Consultation Response from KC Waste Strategy(Refuse & Recycling)
2022/ 91929 rear of, 111, Marsh Lane, Shepley, Huddersfield, HD8 8AS
Part demolition of existing building converted into garage and erection of detached bungalow
Date Responded:20/06/2022
Responding Officer: Mike Hibbert
Responding Ref: WPN 22-26
NOTES/COMMENTS:

Drawn	DRH
Date	May 2022
Scales	1:100 @ A3
Drawing No.	2283 - 0101 - P02

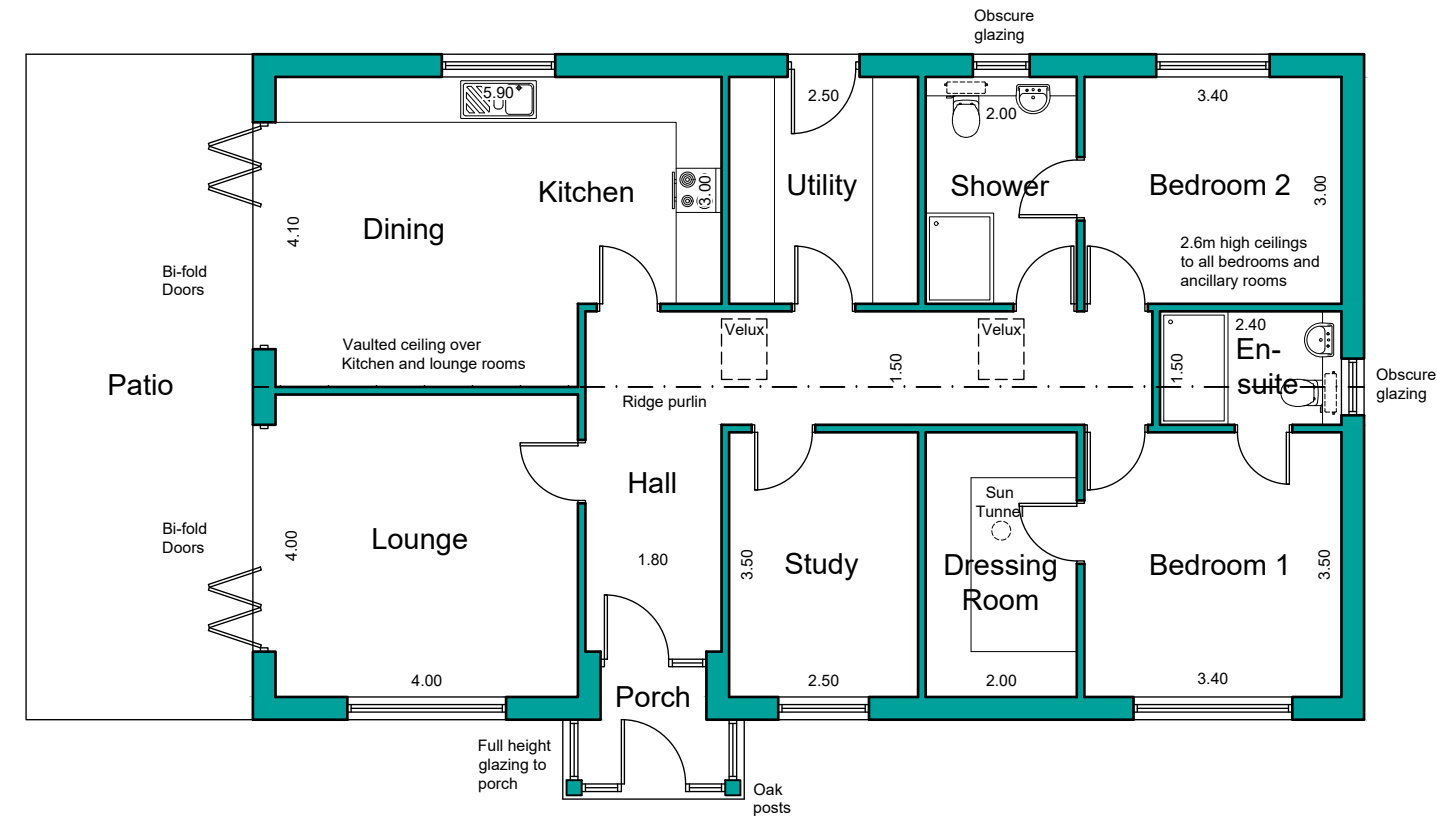
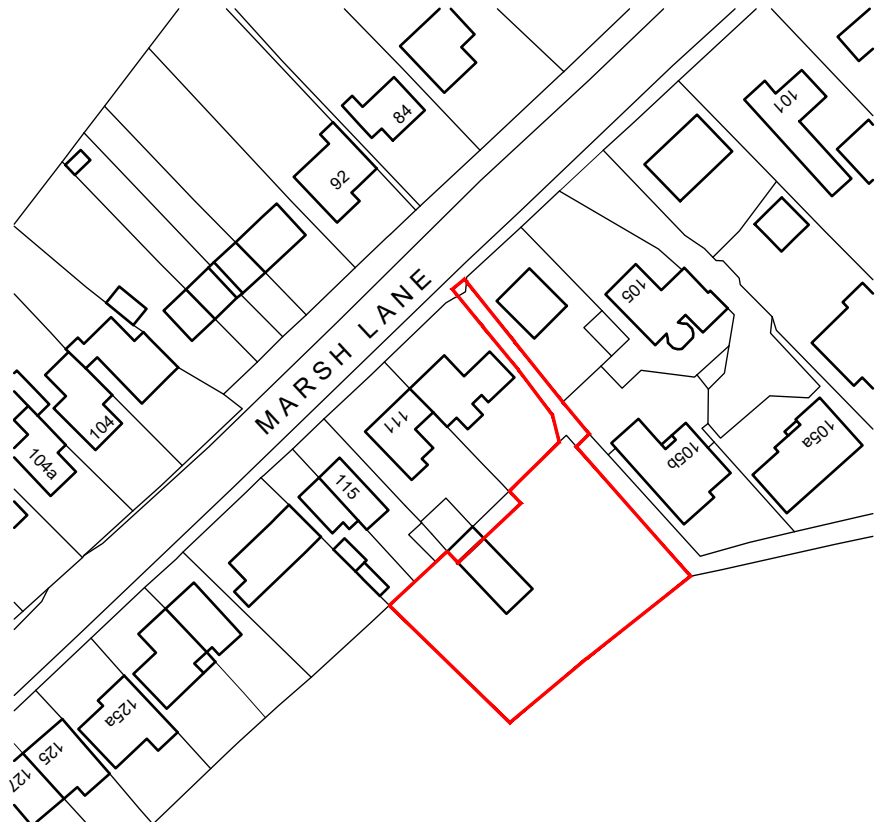
- Page 8 of the Design and Access Statement states Bin storage is accommodated within the site and the bins can be taken along a new driveway to a collection point. Layout drawings for approval will need to show bin storage and Bin Collection Point (BCP) for the dwelling to demonstrate sufficient space and efficient collection arrangements – these must not cause obstruction to the highway, driveways or be blocked in by cars. Guidance indicates wheeliebin storage should be located within the curtilage of the plot.

- The dwelling will require space to store 3 x 240ltr wheeled bins (1x residual, 1x recycling and, as the property has a garden, space to accommodate a garden waste bin) to ensure future waste segregation requirements can be met.

- The Site drawing No2283-0101-P02 dated May 2022 shows access to the property by a private road / driveway. RCV's will not routinely enter private roads.

- On collection day the residents would need to transfer bins to a presentation point close to the adopted highway and not left on the footway.
- A presentation point for wheeliebins located close to adopted highway should be of appropriate dimensions and constructed to the specification detailed in the Kirklees Waste Management Design Guide 2020.
